LOCATION OF CONSTRUCTION: 08-B-6 Vermont Ave., Peaks Island

October 4, 1988

RE: 88-B-6 Vermont Ave., Peaks Island

Your application to construct a single family summer cottage has been reviewed and a permit is herewith issued subject to the following requirements:

KILLINGTON

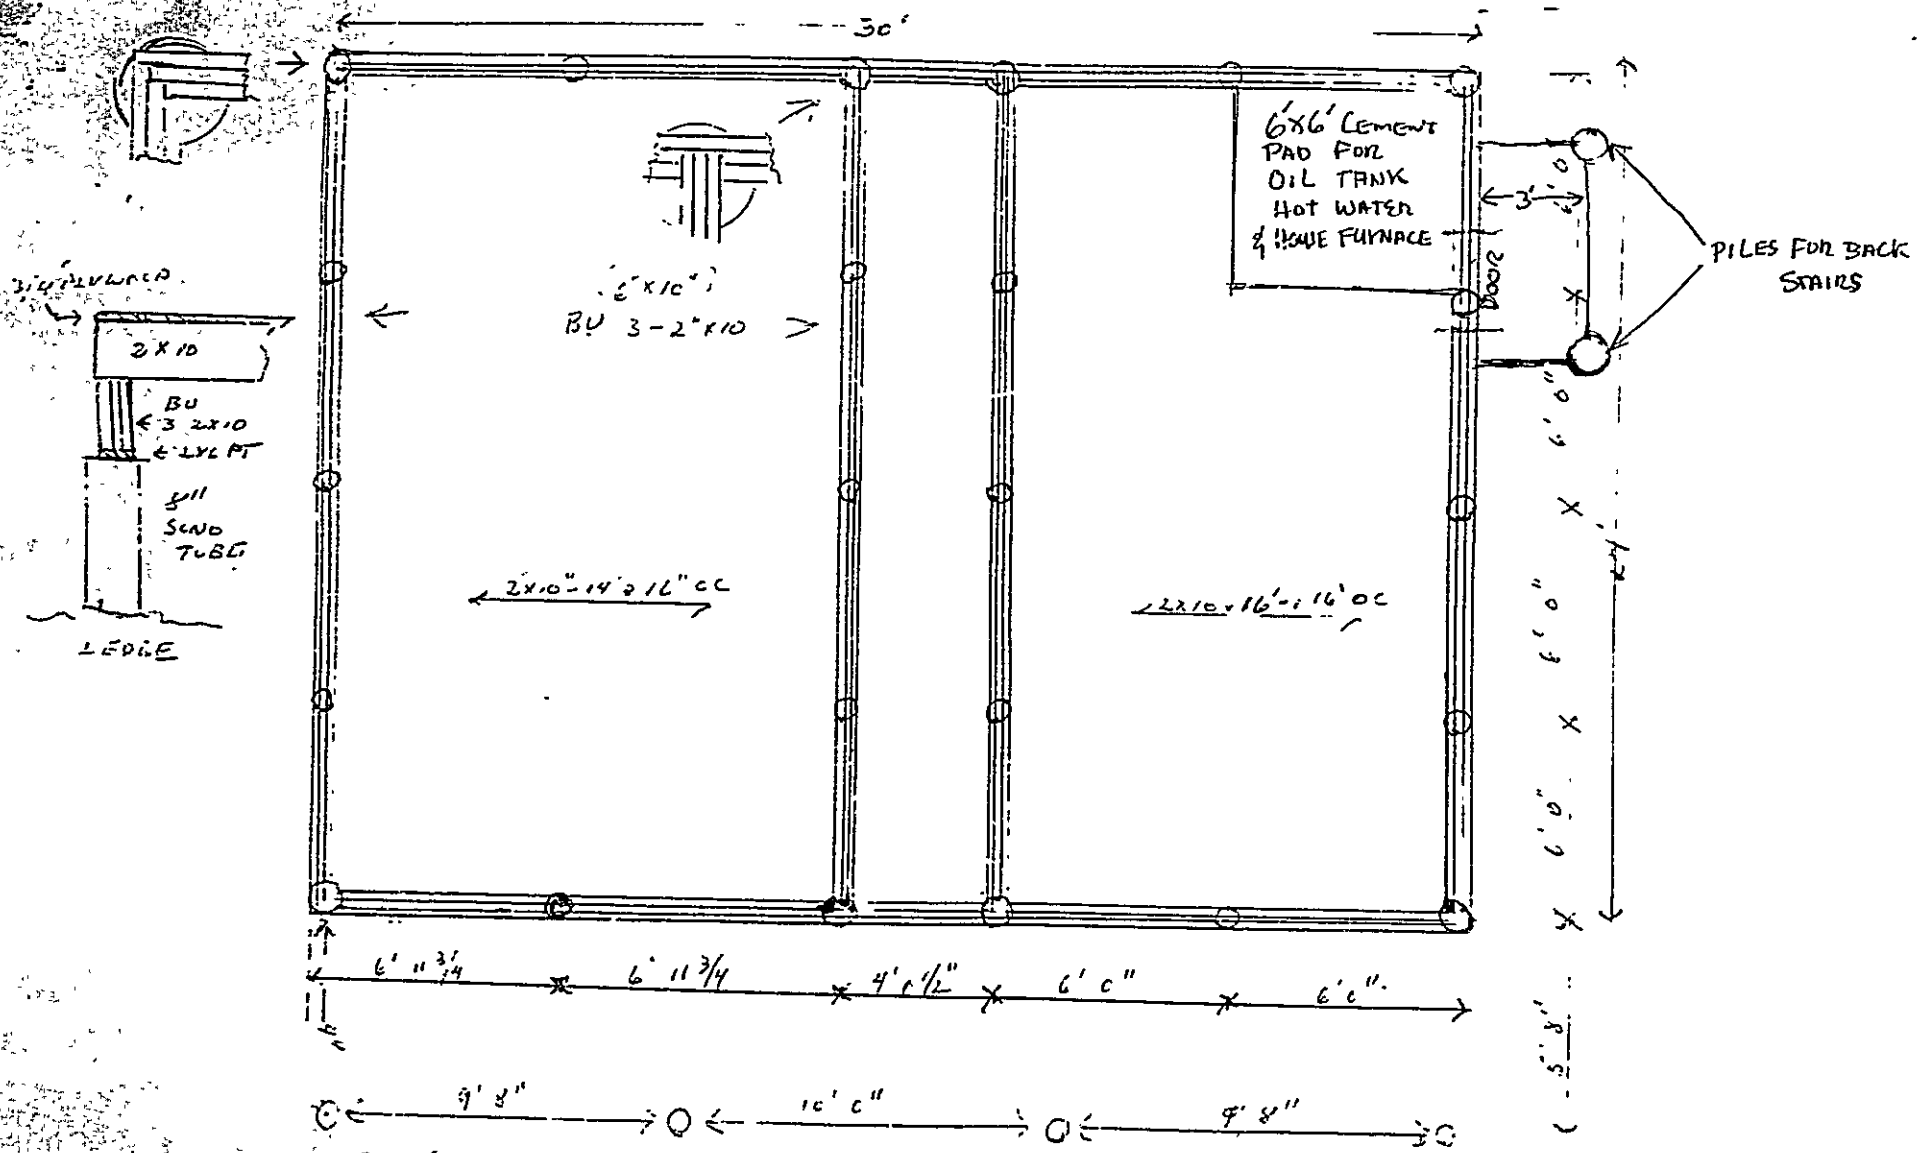
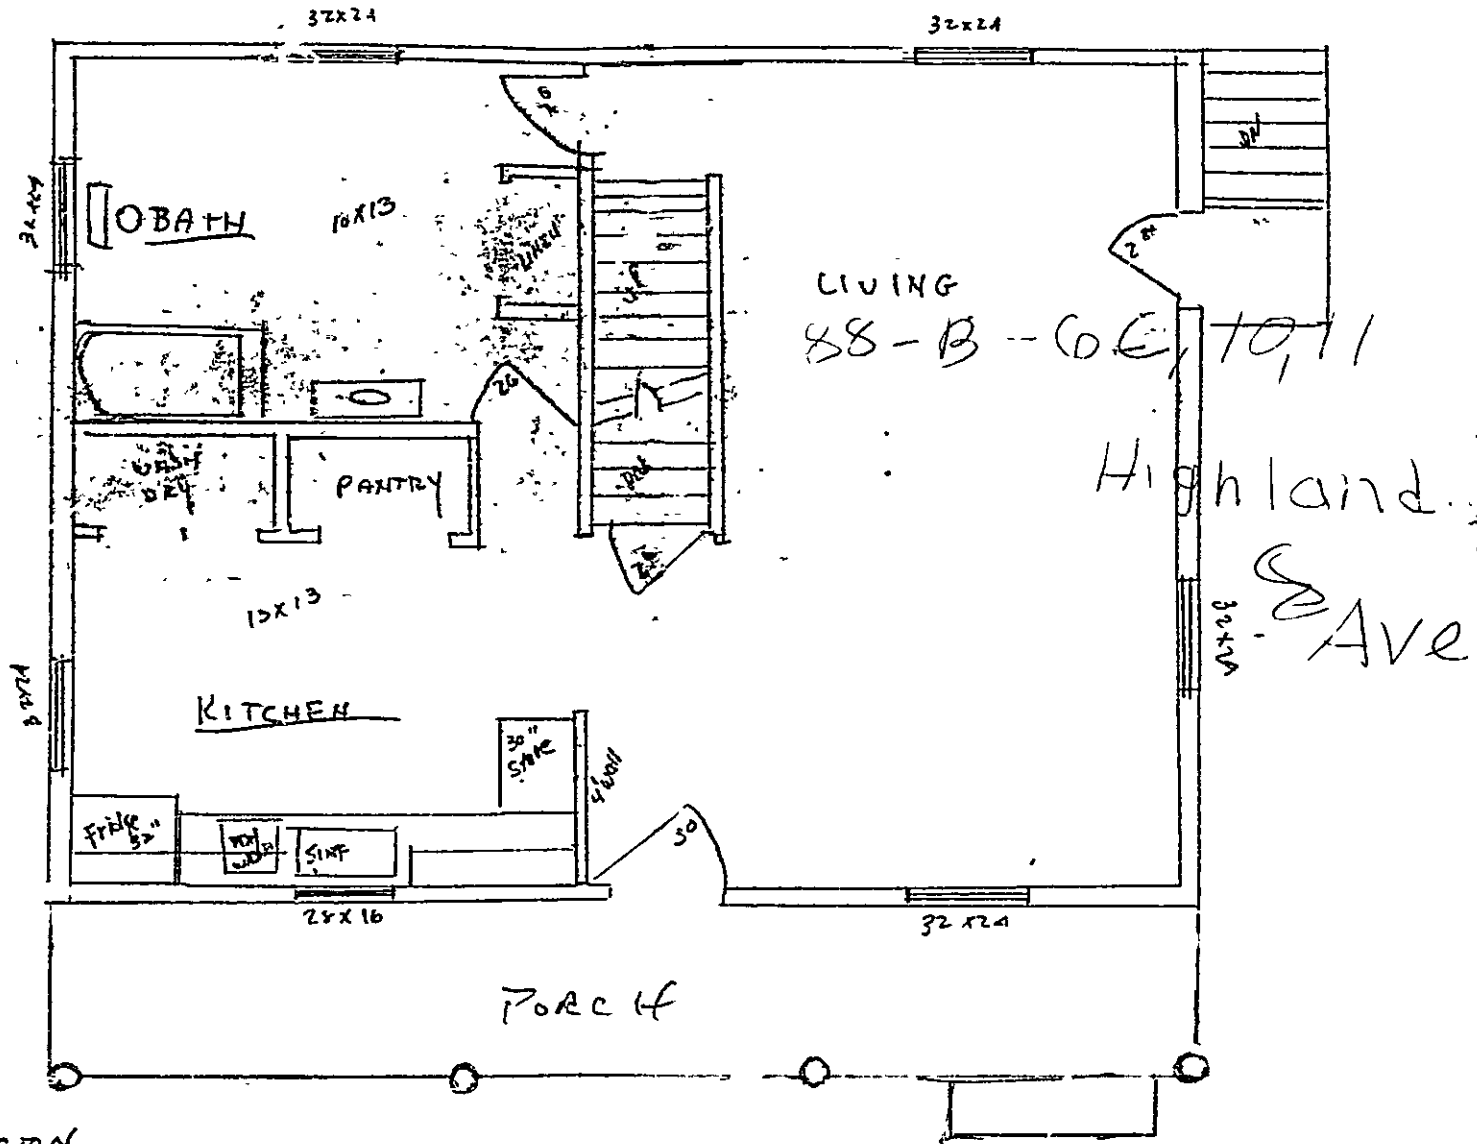
1. Please read and implement items 4 & 5 and 7 of the attached building permit report.
2. Before placing foundation all setback must be approved by inspection services and elevations by Public Works.
3. The rafter shown on your plans are 2" x 6". A minimum of 2" x 8" at 16" o.c. must be used in th's spec.
